## PLAN EXAMINATION CONDITIONAL APPROVAL

**PROJECT/SITE DESCRIPTION:**  
Maine Medical – Visitor’s Garage Extension

**PROJECT ADDRESS:**  
22 Bramhall St – Portland, Maine

Review Type:	All Trades
Plans Date:	3/30/18
# of Sheets:	96
Project Area (sq. ft.):	82,201

1 SOUTH ELEVATION

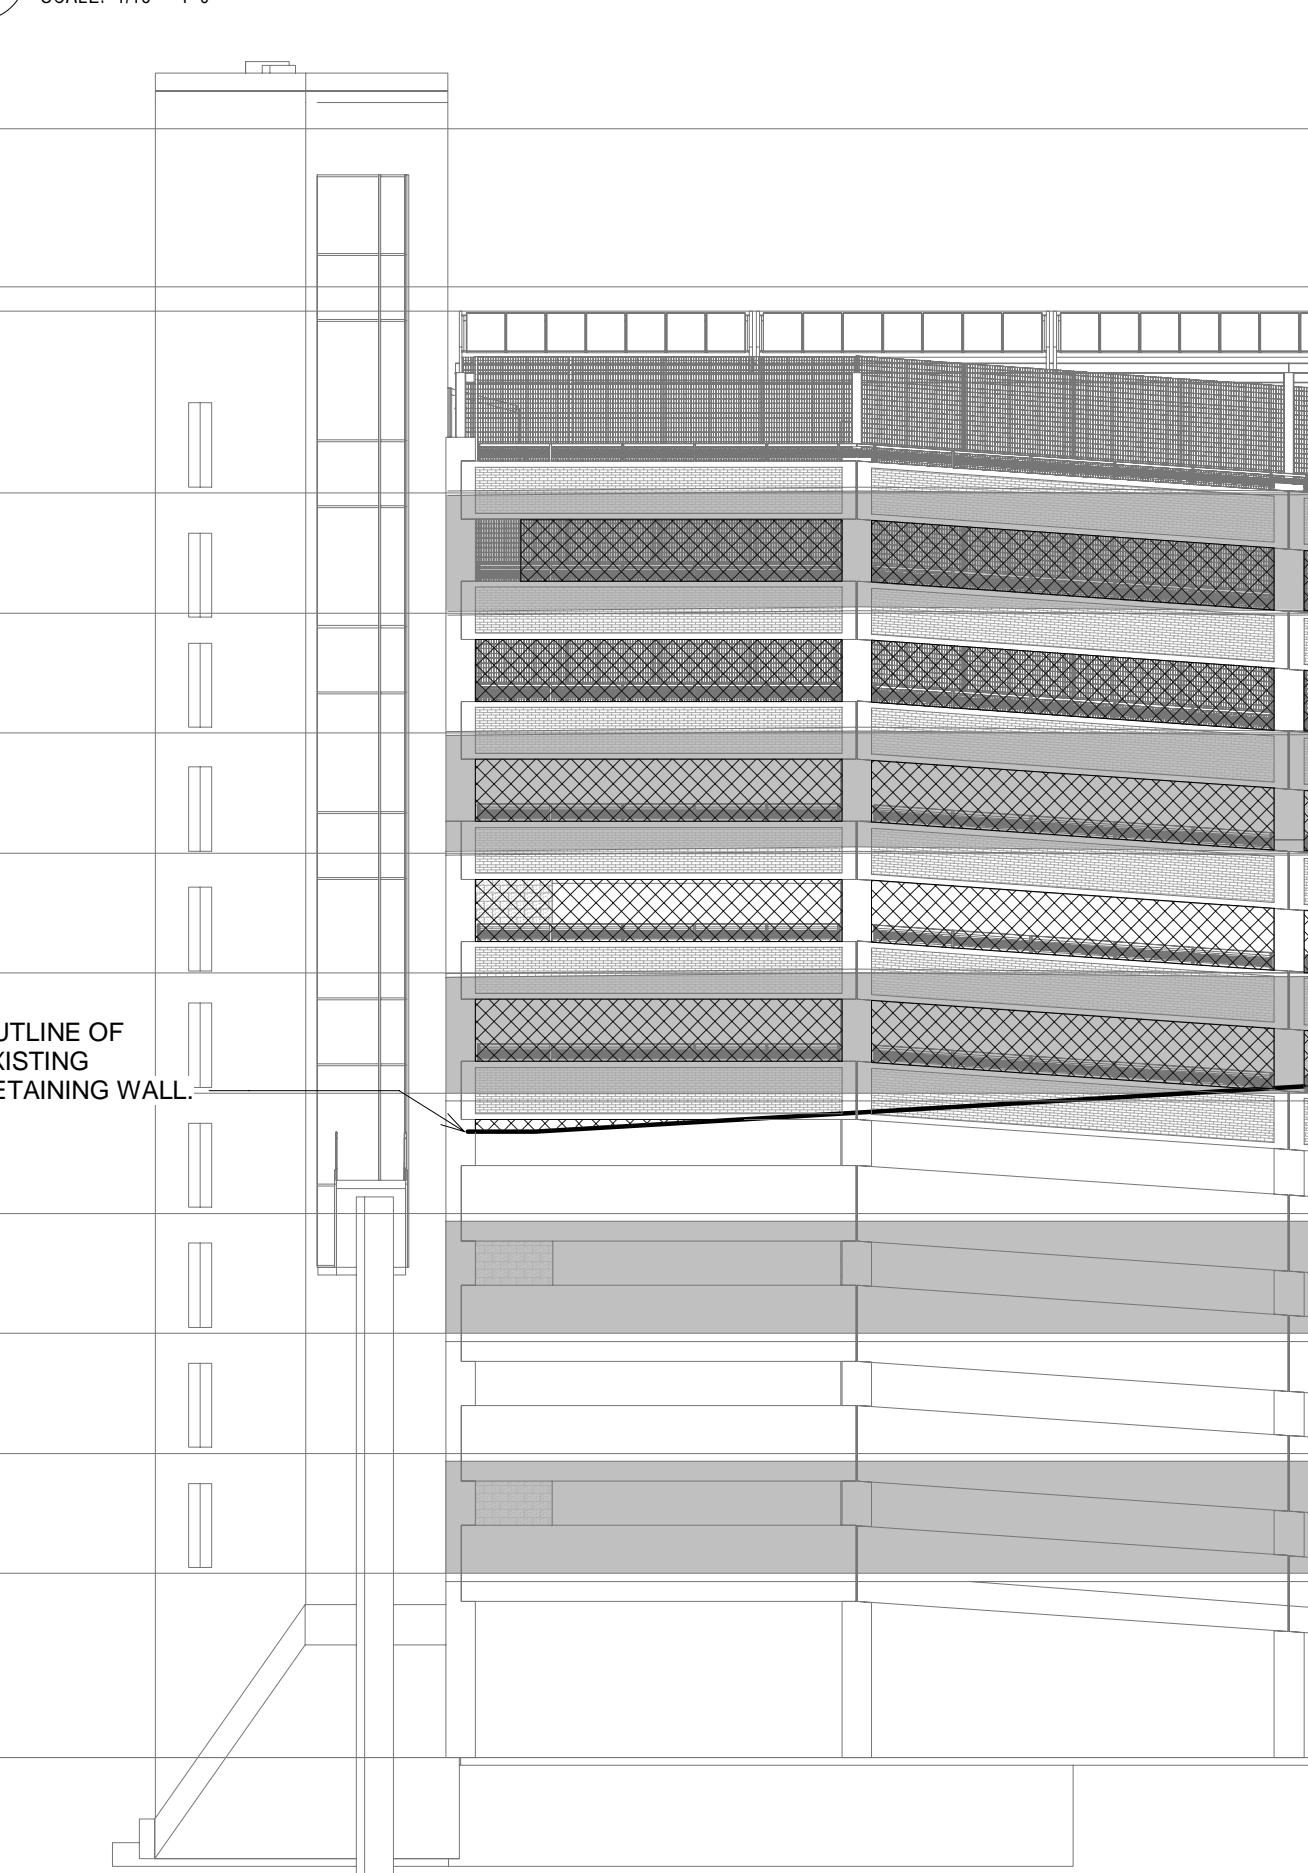
Plan Review Comments are based upon updated G02-01 Code Compliance Elevations sheets provided during review 3/27/18 demonstrating ventilation requirements meeting code requirements to allow for structure to be considered as an "Open Parking Structure".

The review of the above referenced project is for an open parking structure as clarified in revised G02-01. The plans submitted were architectural only. Shop drawings and calculations were not included in the submittal. They will be considered a differed submittal.

The review of the above referenced project is for an open parking structure as clarified in revised G02-01. NFPA 1, NFPA 101, NFPA 88A are the referenced applicable standards.
